From: Laura Gibbons <Laura.Gibbons@arun.gov.uk>
Sent: 16 March 2021 09:44
To: Planning.Responses <Planning.Responses@arun.gov.uk>
Cc: Michael Eastham <Michael.Eastham@arun.gov.uk>
Subject: RE: Planning Consultation on: Y/26/21/DOC

Thank you for consulting us on this discharge of conditions application. We have the following comments regarding condition 11.

Application No: Y/26/21/DOC

Description of Works: Approval of details reserved by condition imposed under ref APP/C3810/W/17/3170059 (Y/80/16/OUT) relating to Condition No 11 - maintenance & management of sustainable drainage scheme.

Job Title			
FORD LANE, YAPTON			
Drawing Title			
SURFACE WATER CATCHMENT AND IMPLEMENTATION PLAN			
Client			
REDROW			
Scale	Date	Designed	SG
1:500 @A0	JAN 2020		
Drawn	Checkd	Approved	LH
LP	SG		
Job No	Drawing No	Rev	H
18-344	18-344/108

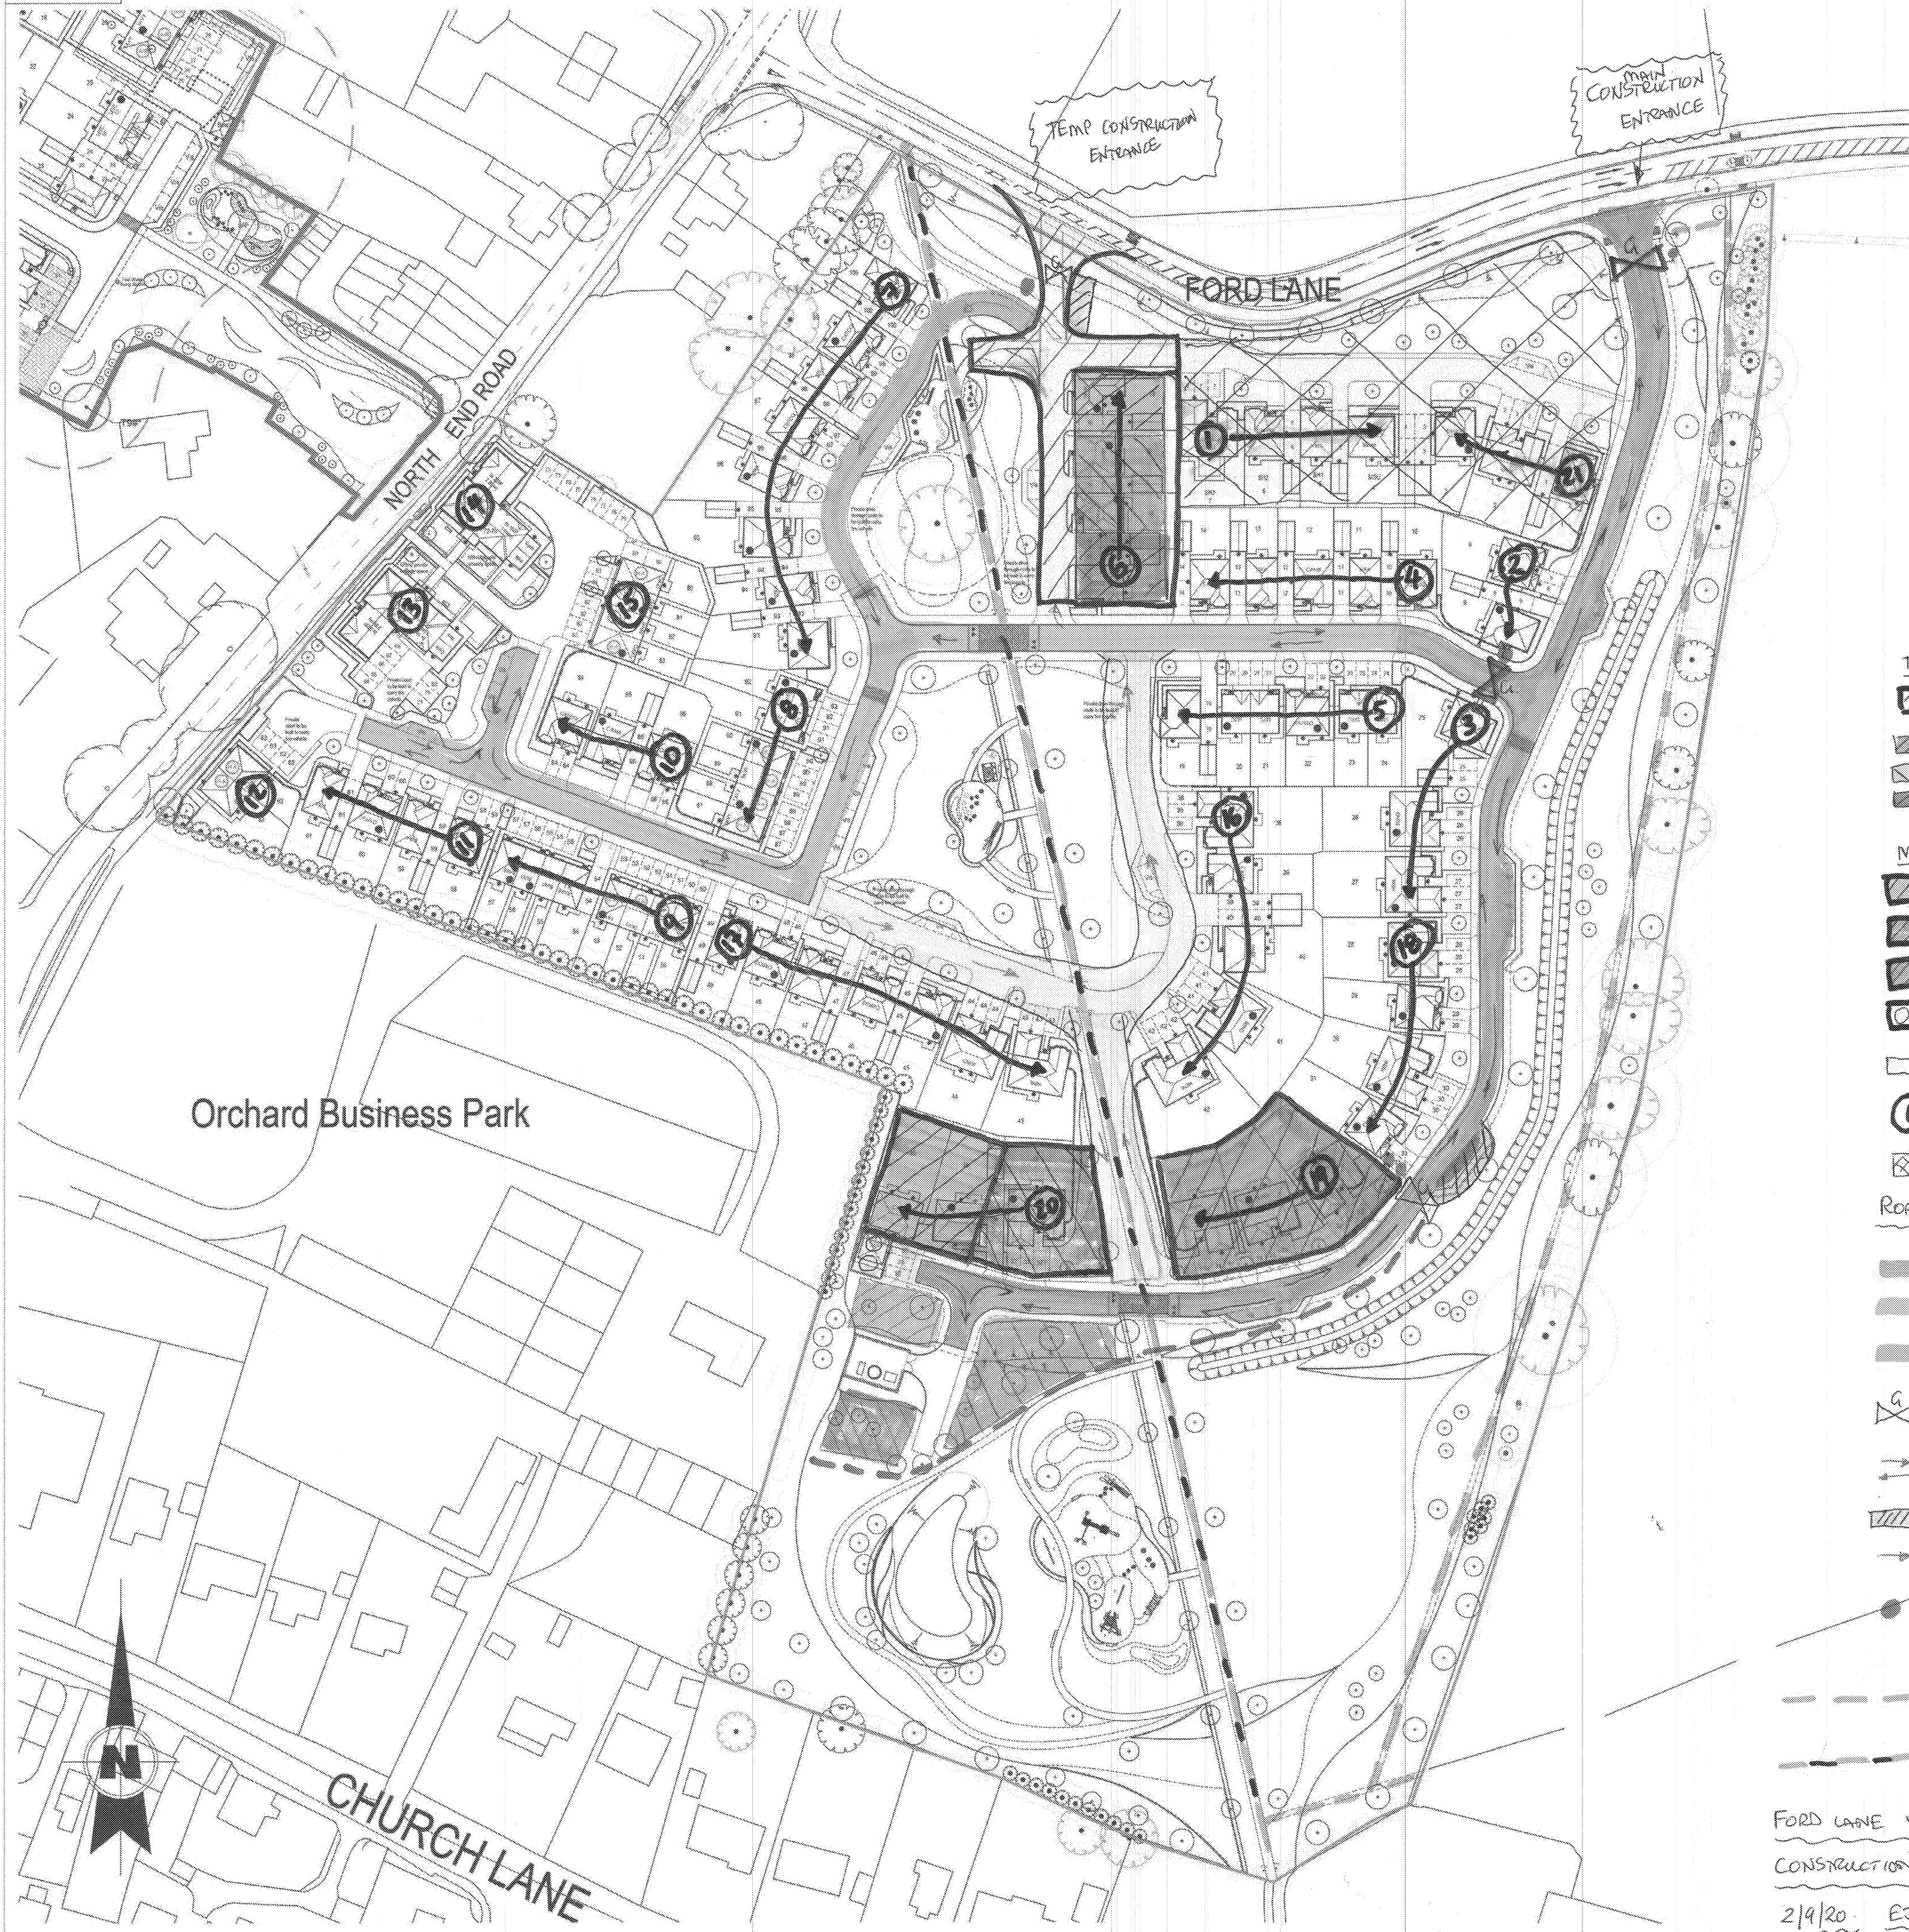
The calculations for road areas are not clearly defined, please label road 1, etc. on plan. Impermeable areas diagram does not clearly show which areas are draining to where, i.e. please break down the road area into the catchments modelled. Please clearly show road areas numbers on drainage layout drawing.

Road 4 has an unacceptable half drain time. Impermeable area modelled is greater than permeable paving area, please clarify why this is the case.

Road 5 has an unacceptable half drain time. Impermeable area modelled is greater than permeable paving area, please clarify why this is the case.

Road 5 plus plots 85-92- area is not clearly defined on the impermeable area plan, the modelled infiltration rate is not representative of the results from the nearest infiltration test. Diffusers are set too low in the sub-base (i.e. below 1 in 10 yr plus cc water level).

2. Please provide an impermeable areas plan in dwg format. Please also state areas on the impermeable areas plan (pdf and dwg). Impermeable areas have been added to catchment plan key. DWG also provided in link above. *Please see comments above, please better define your catchments so it is clear what areas are draining to what road areas.*

7. Why do some plots have diffuser blocks located in the drive, and some in the road? E.g. around plots 51-60 and 79-82? Surely they all need to go through to the road as you have not shown additional linkages with diffuser blocks through these service corridors. They are based on offsets, storage volume and catchment. Driveway was preference but if could not be met then linked to road. *Please better define impermeable areas draining to road/ drive areas.*
